13 November, 2019

Mr Rodger Roppolo,  
Department of Planning, Industry and Environment,  
GPO Box 39,  
SYDNEY NSW 2001

SSD-8924 – New Sydney Fish Markets – Concept Proposal and Stage 1 Works

**Diagram : Proposed Relocation Of Rowing Route**

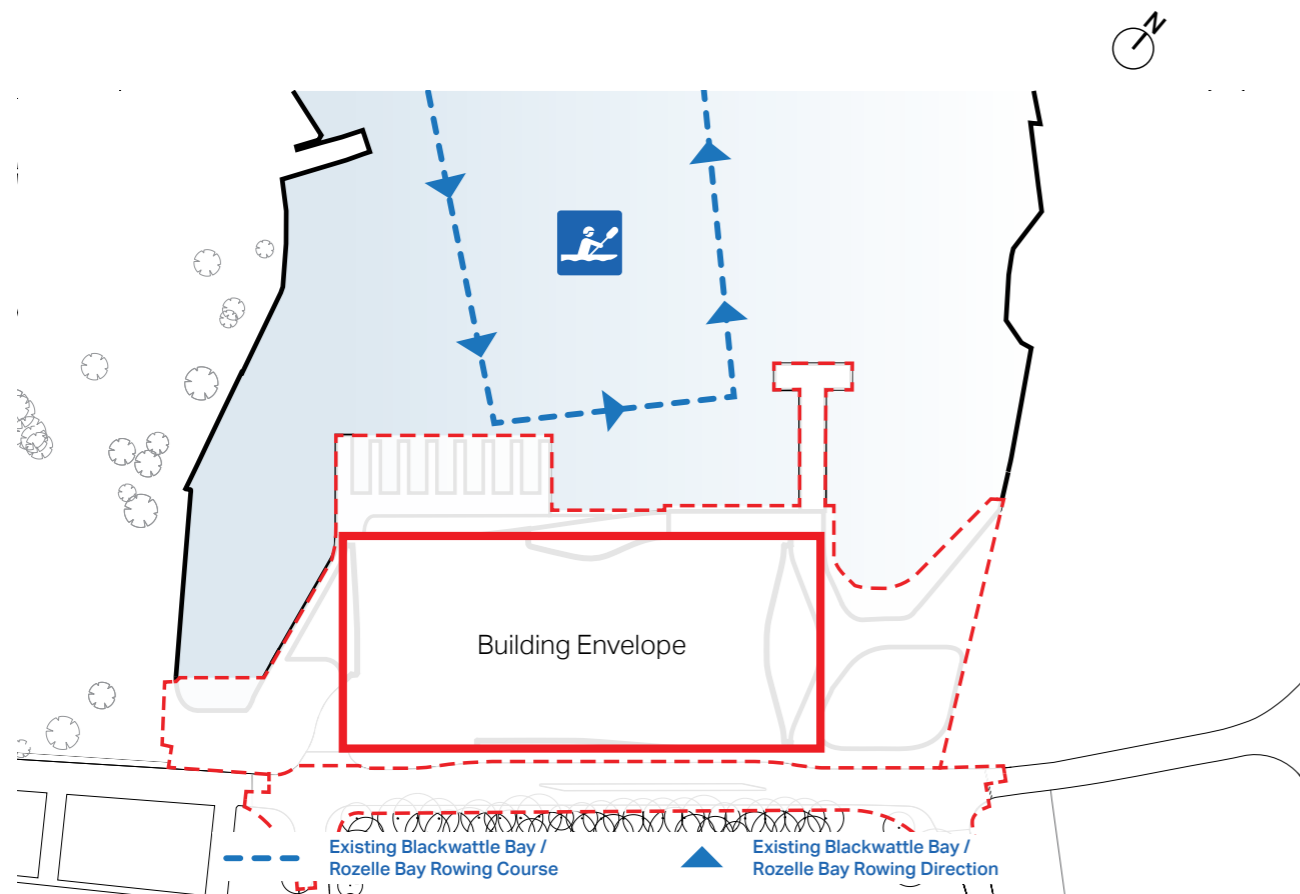
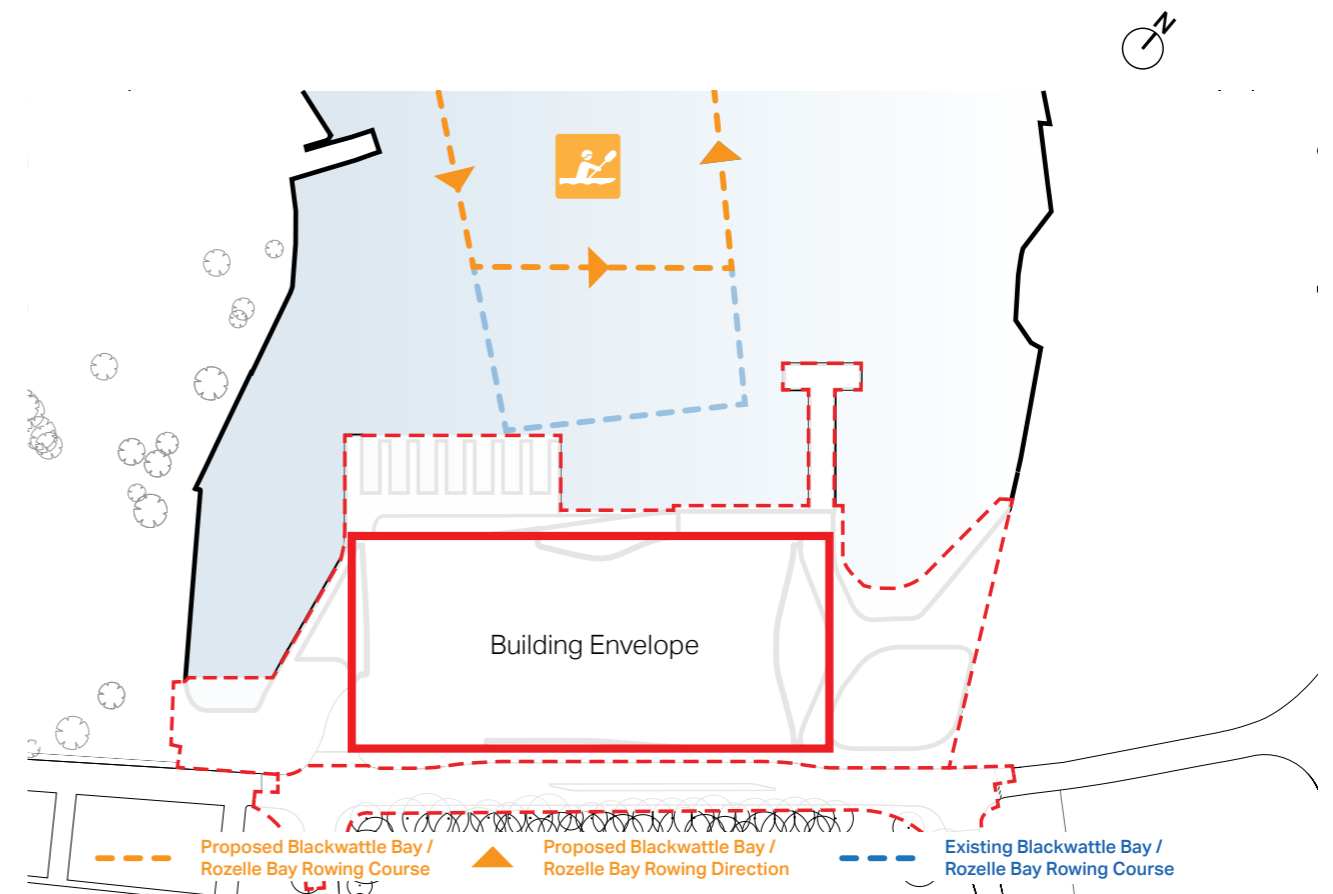
Passive Boating – We are concerned to note that the development will require a permanent shortening of the rowing route at the head of Blackwattle Bay to maintain a minimum distance of 45-50m between the route and the proposed wharf structures (EIS p130). Elsewhere (EIS p54) it is stated that representatives of the rowing groups have expressed their concern and that all parties are to consider solutions and meet to resolve the issue. It should be acknowledged that Glebe Rowing Club has been operating in the bay since 1879.

If the rowing route is shortened, rowers will be unable to train in a competitive environment, and regattas such as one held in Blackwattle Bay several years ago, will not be able to be accommodated in the future as the route will not be of an appropriate length for competitions.

*Recommendation 10: The wharf configuration should be revised to ensure that the operations of the rowing clubs are not curtailed.*
